Work Change Proposal Request

PROJECT:
Nephrology Associates Renovations
Portland, Maine

PROPOSED REQUEST NUMBER: 2

Code Clarification Revisions

**DOOR & DOOR FRAME SCHEDULE**

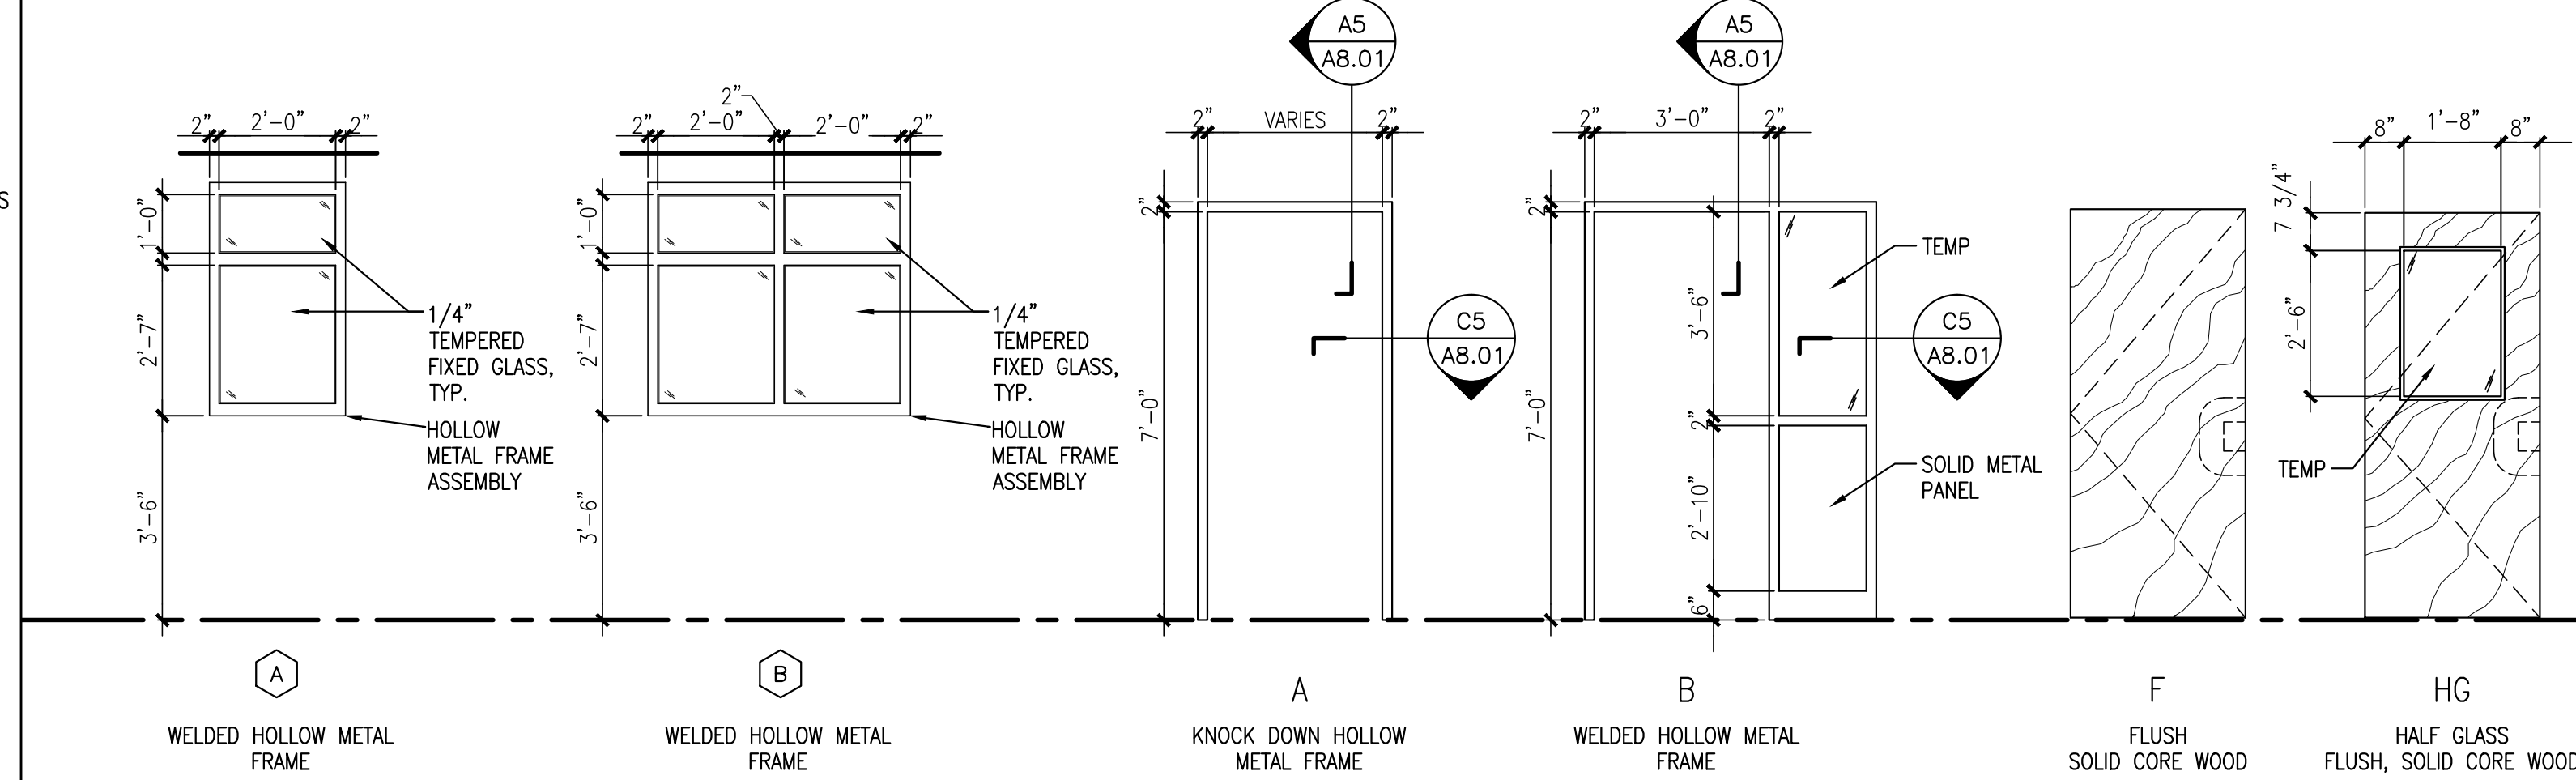
Item No. 1: The contractor shall revise the fire rating of all new doors within Corridor 152 from 45 - minute doors to 60 - minute fire rated door units. This applies to doors 151B, 152A, 152B, 152C, 152D, 152E, 152F and 143.
